**85 HARRINGTON STREET,
THE ROCKS**

**RESPONSE TO
SUBMISSIONS**

9 AUGUST 2017
FINAL REPORT
PREPARED FOR GOLDEN AGE & HANNA THE ROCKS

Quay West View Analysis

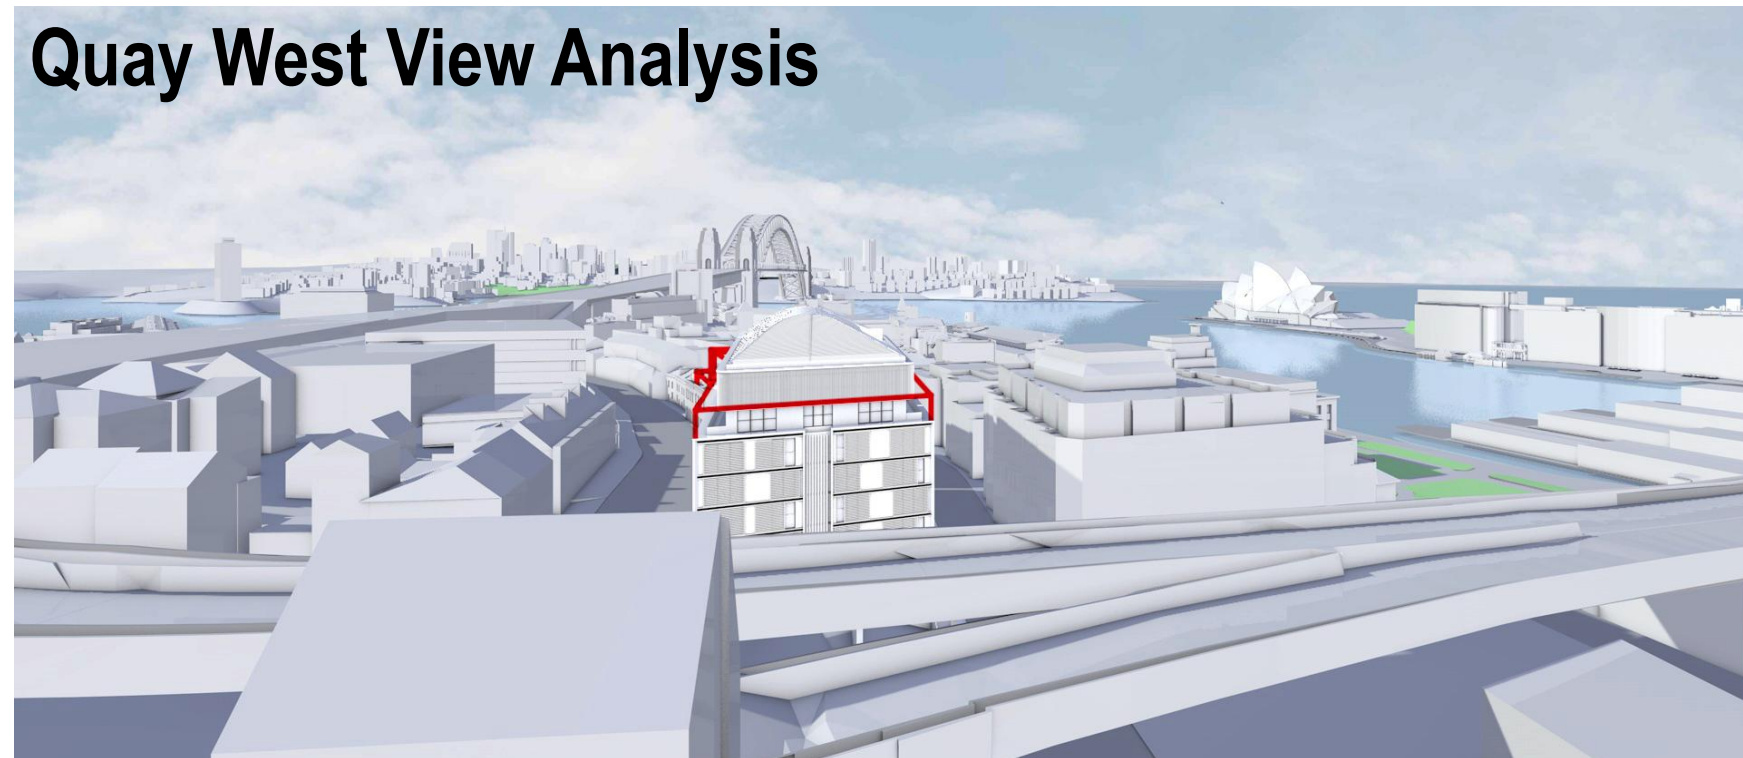
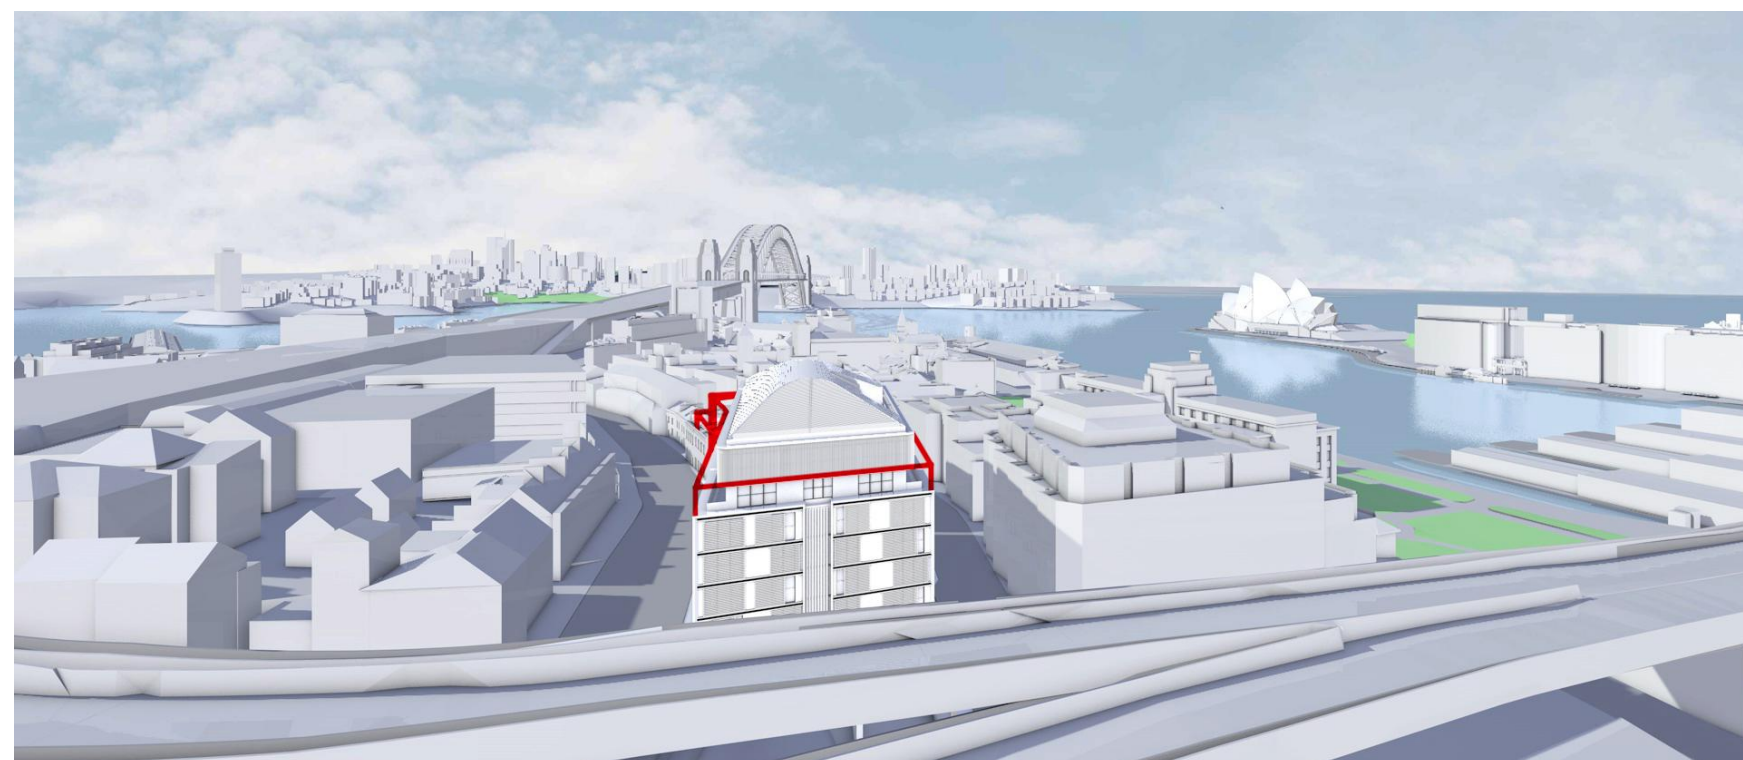
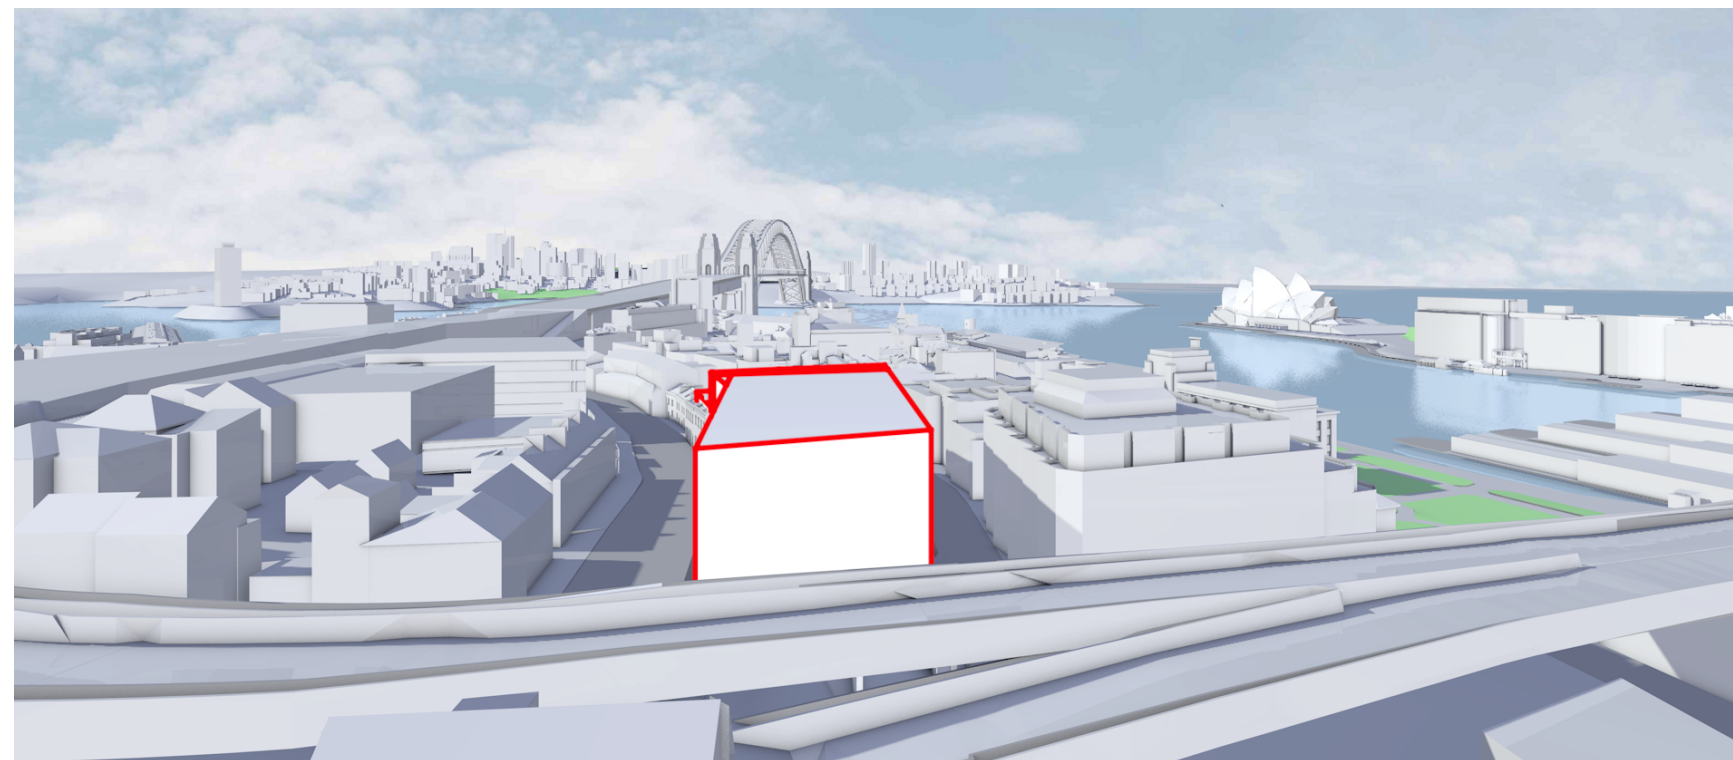
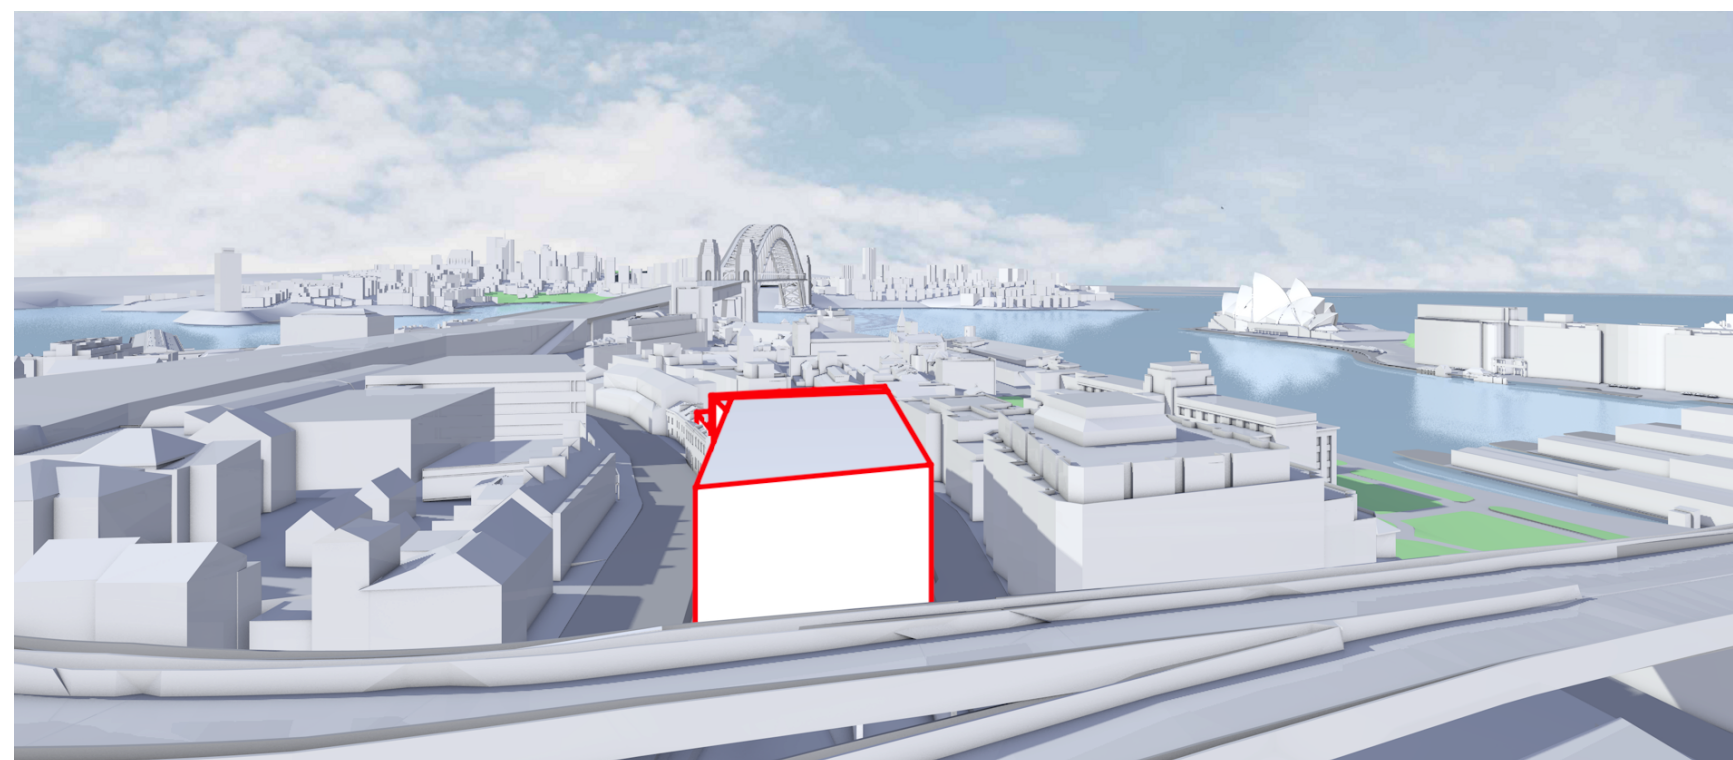
- **Potential adverse view impacts from Block 1 height not examined** – As discussed in Section 3 of this report, FJMT have examined the potential view impacts on properties located to the south of Cahill Expressway that may be affected by the proposal. The proposal will have very limited impacts on these properties (which are all commercial use in nature – i.e. hotels or serviced apartments) and these views would not be unreasonable in accordance with view sharing principles established by the NSW Land and Environment Court.

- **View impacts on residential properties to the south of Cahill Expressway** – We note that the Department of Planning have not raised this item, and there have been no public submissions which identify the proposed height as having any unreasonable impacts on views shared through the site. However, FJMT have provided a range of images in the Design Report which indicate that most of the properties immediately to the south of Cahill Expressway are commercial in nature (i.e. the Shangri-La Hotel, Quay West Serviced Apartments, and the Four Seasons). The before and after images provide that there is very limited impacts on views enjoyed from these properties, and the majority of views of important icons such as the Opera House and the Sydney Harbour Bridge are largely maintained.

The view analysis by FJMT provides that there will be potentially 2 lower levels (out of 37 floors) of the Quay West Serviced Apartments which will have a reduced view of the Sydney Harbour Bridge, however, these still maintain iconic views of the Sydney Opera House. On balance, this is a very limited view impact given that the surrounding context and not considered unreasonable under the circumstances.

1 ELEVATION North Elevation Block 1
1:200

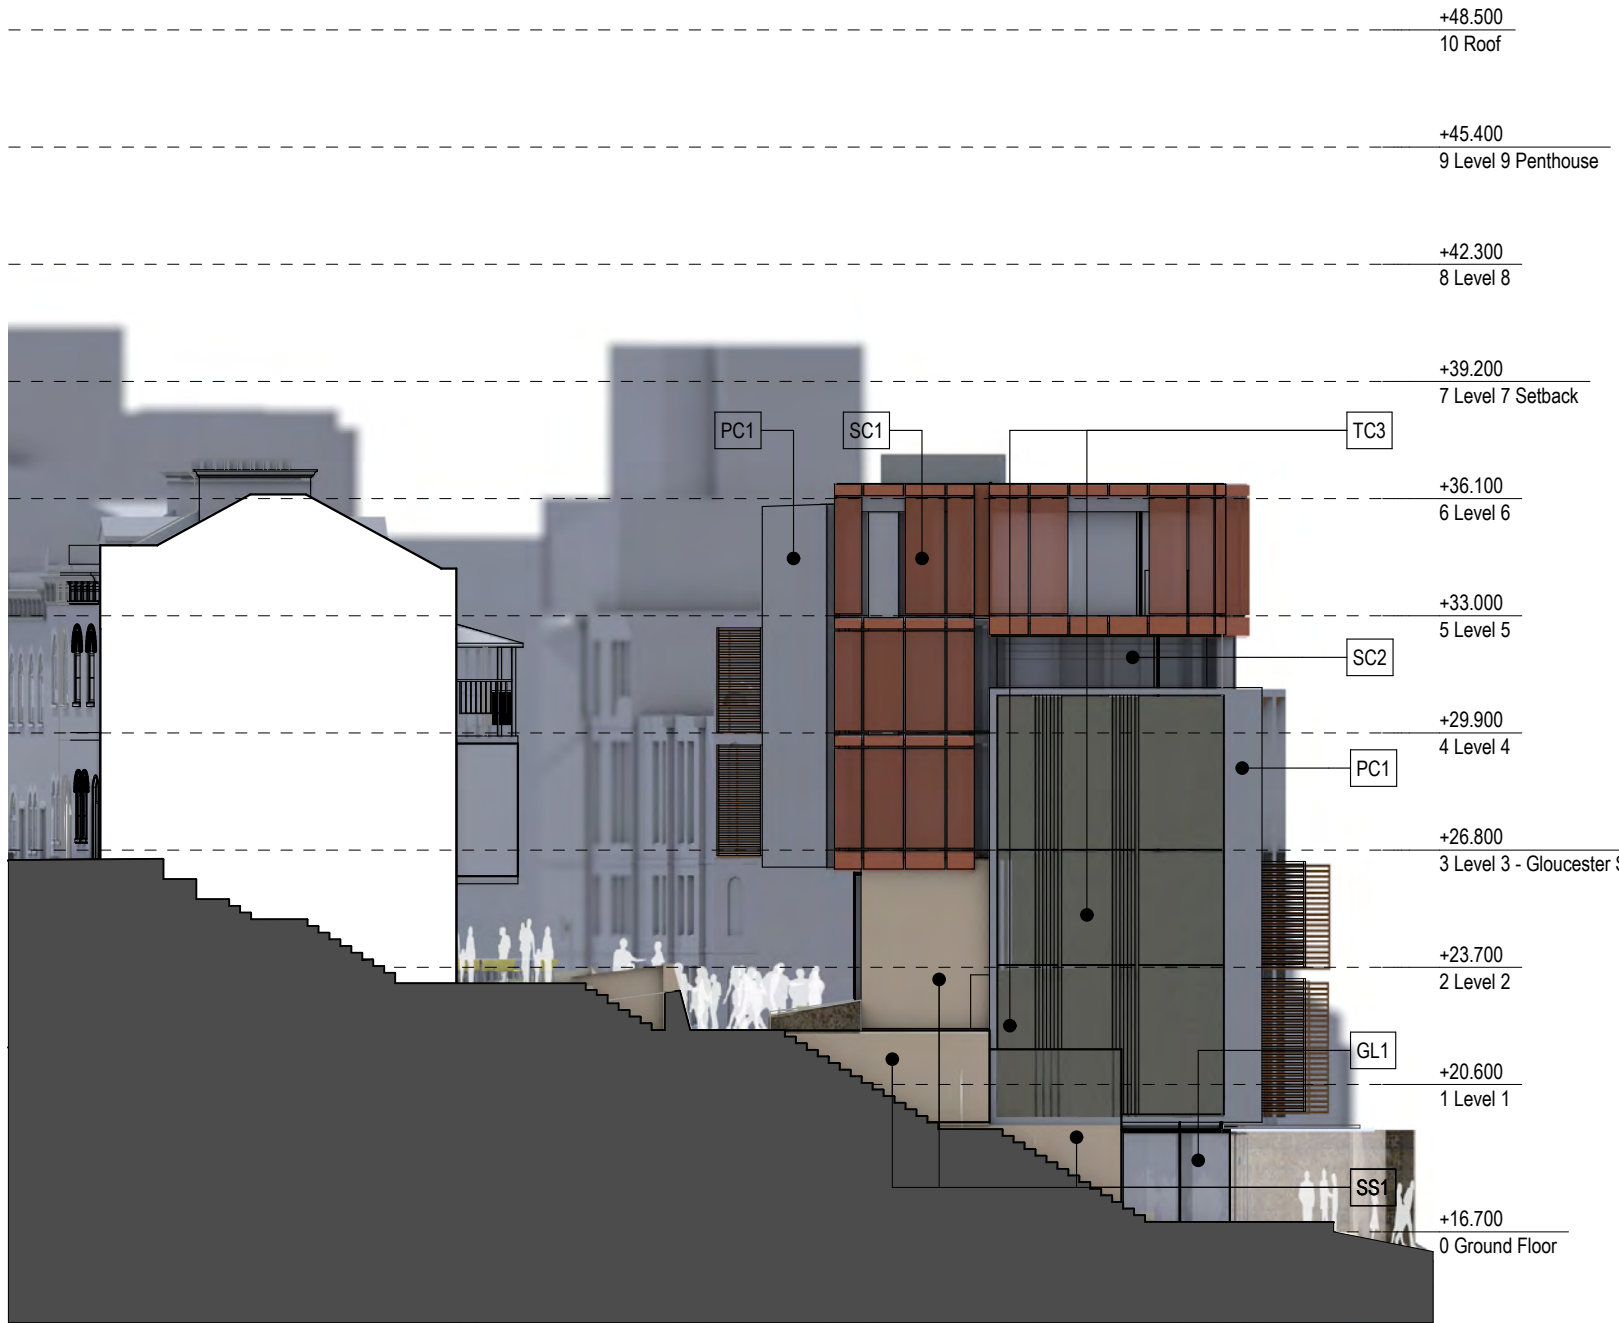
In terms of the site's immediate neighbour to the north (The Rendezvous Hotel on Harrington Street), we note that the leaseholders of this site (Far East Land Australia) have queried the building separation adjacent to their property. Both The Rendezvous Hotel and 85 Harrington Street (existing) are both built to the boundary of Cumberland Stairs.

The Rendezvous Hotel has some side windows adjacent to the Cumberland Stairs, however these appear as secondary windows, and rooms with balconies face Harrington Street. The proposed apartments will provide privacy screening which will reduce the opportunity for overlooking. The northern elevation is shown in the figure on the following page.

Figure 3 – Operable shutters and upper level recess on the northern elevation adjacent to The Rendezvous Hotel to minimise overlooking

Therefore, the proposed separation is considered reasonable for the following key reasons:
